Your Reference: SSD 16_7942
Our Reference: NCA/4/2017
Contact: Myfanwy McNally
Telephone: 9806 5447

8 September 2017

Re: URBN SURF - Open Water Surf Sports Lagoon Facility, Pod B, Part of P5 Carpark, Sydney Olympic Park NSW 2127

| Title: 50lux min MH=25m | Designer: AP | Date: 3/9/2017 |

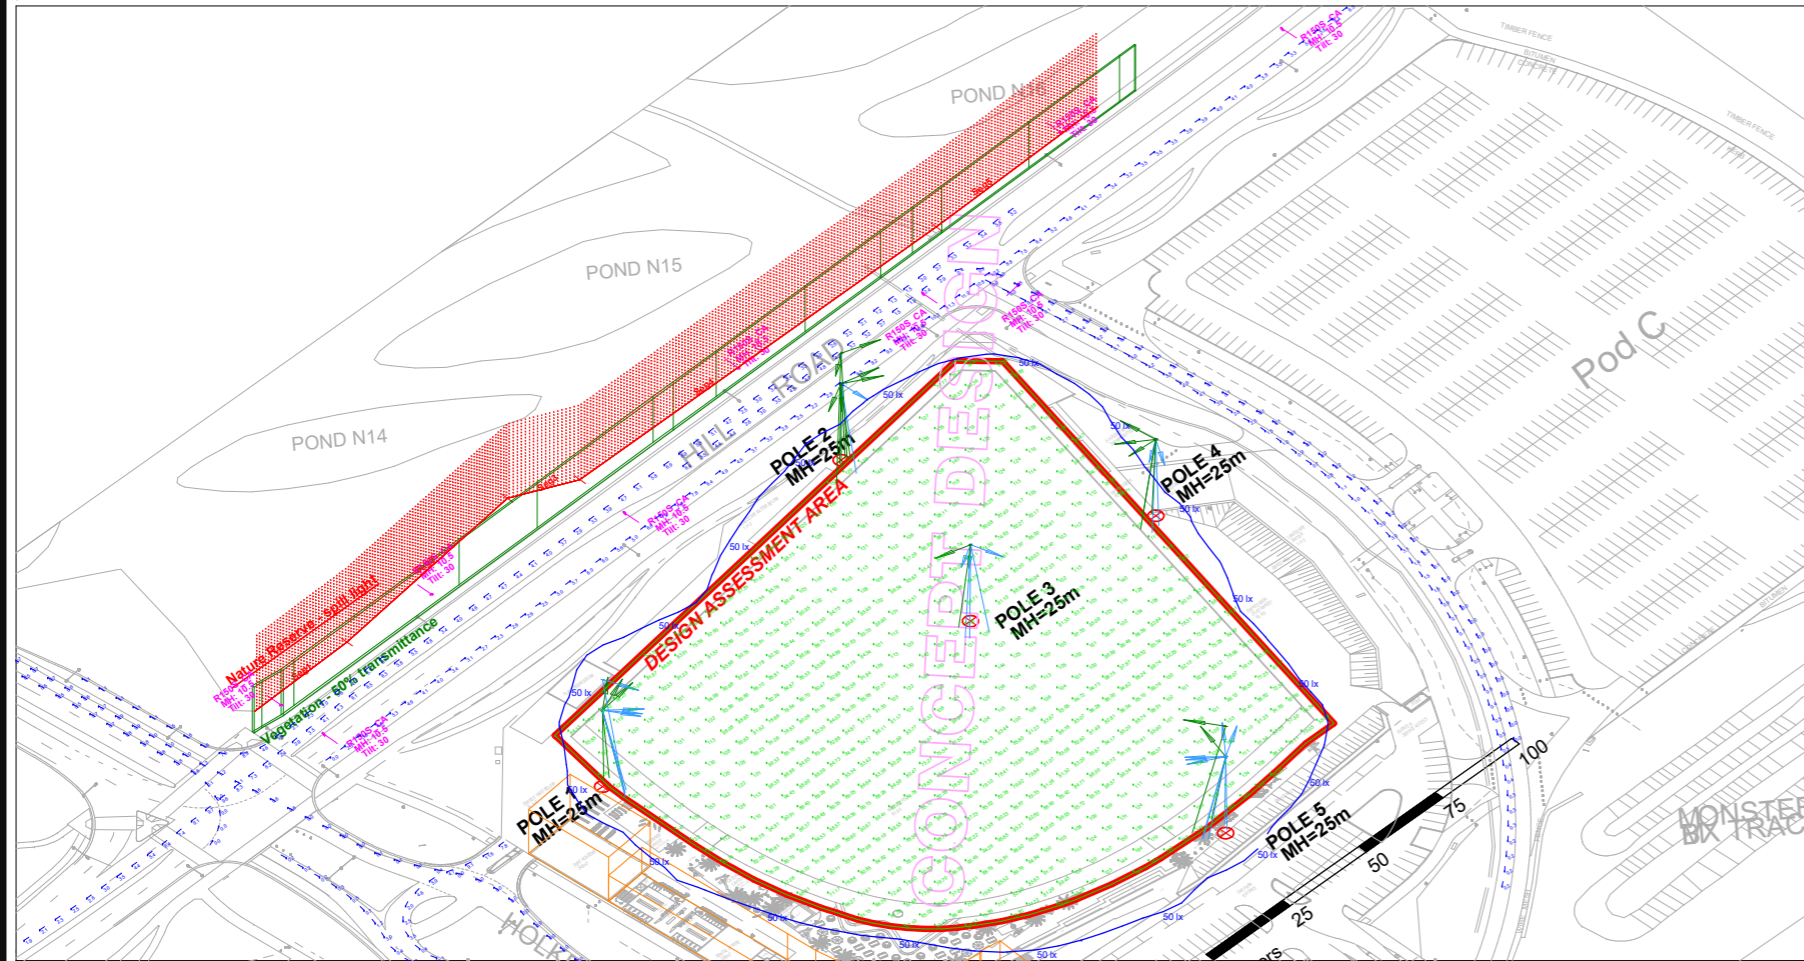
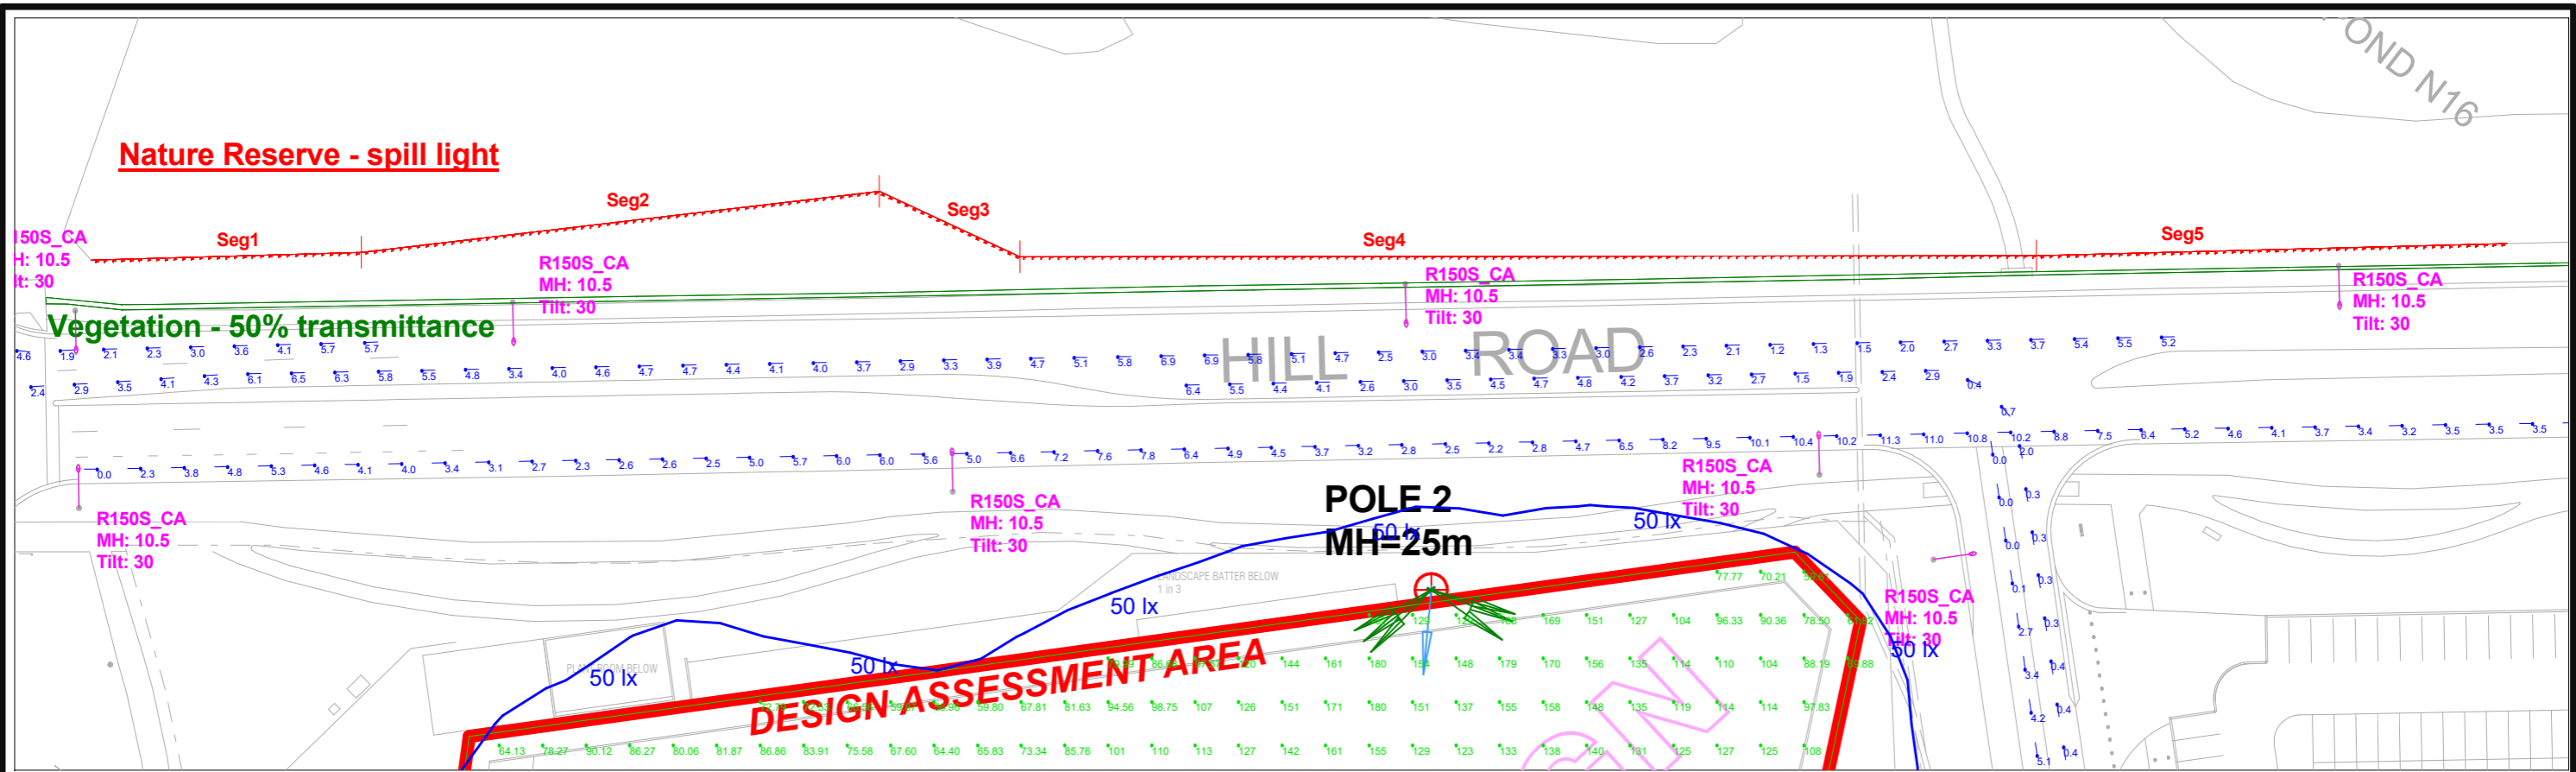
Car park facilities need to incorporate clearly defined pedestrian access paths, directional signage and balanced lighting to offer pedestrian safety whilst minimising light spill on the surrounding natural environment as per AS4282: 1997 (Control of Obtrusive Effects of Outdoor Lighting).

Biodiversity	<p>The biodiversity assessment is accepted as provided.</p> <p>The only question is: What is the strategy if ducks use the lagoon when waves are turned off? This is also a public health issue.</p>
Light pollution	There is a need to minimise up-lighting/ pollution. Night use expected, but no clarity around how light pollution be controlled or managed.
Building and infrastructure re-use for alternative purposes	Building such a specific-purpose development comes with risk. If the project fails commercially in 5 years or 15, what are the smart-re-use options for the facilities, including the lagoon, have been considered? Can it be re-purposed for commercial or even environmental – passive recreation purposes?

Figure 3: Site plan for the proposed facility (Source: EIS)

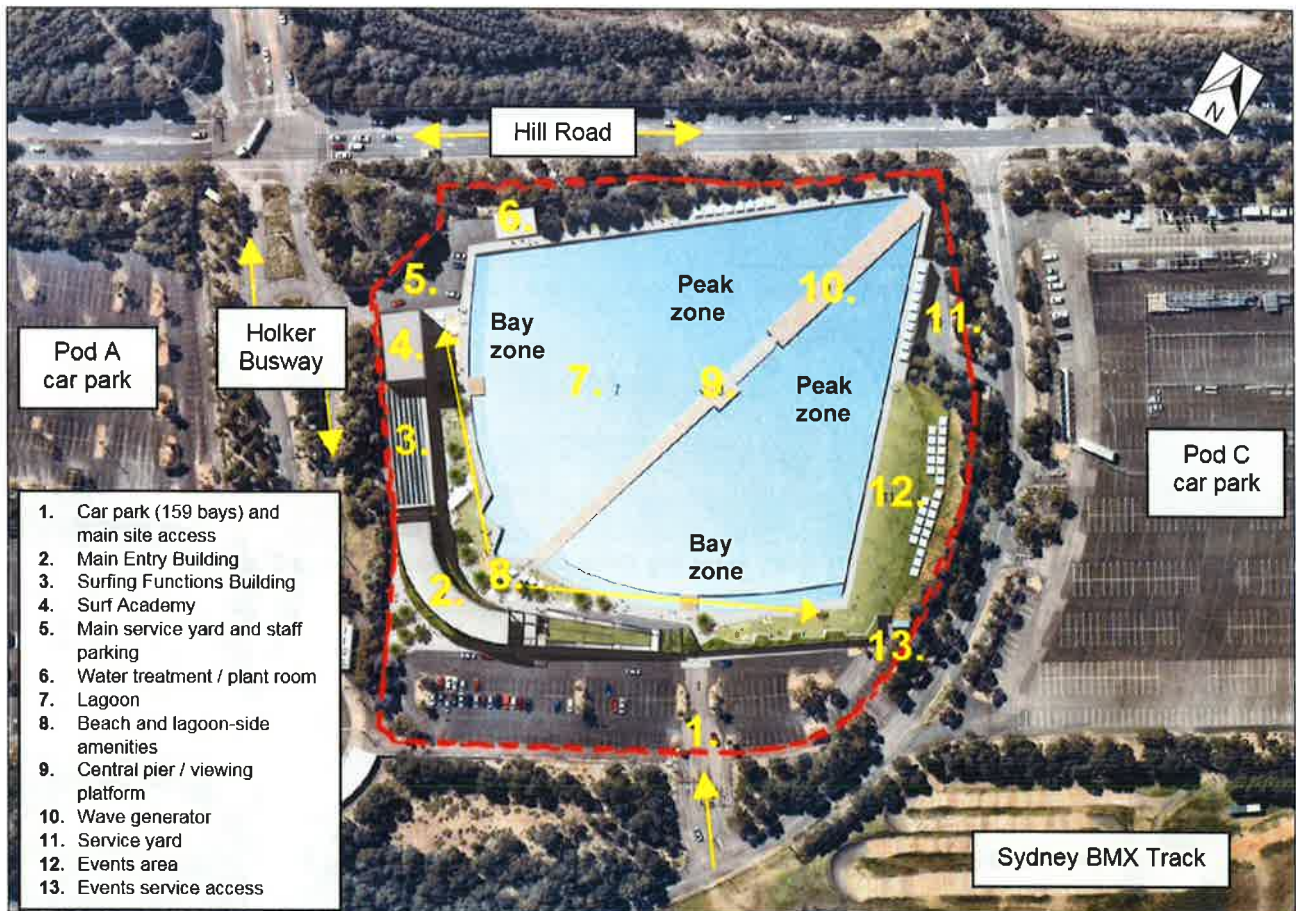
Staff parking is to be provided within the general car park, rather than having the additional small 7 space car park at the service entrance. As the use of the busway to access these 7 parking spaces could conflict with the future Light Rail initiative.

The shade offered by tree planting is insufficient in the zone 1 car park, the eastern boundary lagoon deck area, the children's play area and the activity nodes used for layout and seating of patrons on the site.

Screen planting is encouraged on the site boundary to cover the unsightliness of the proposed plant room and southern public carpark.
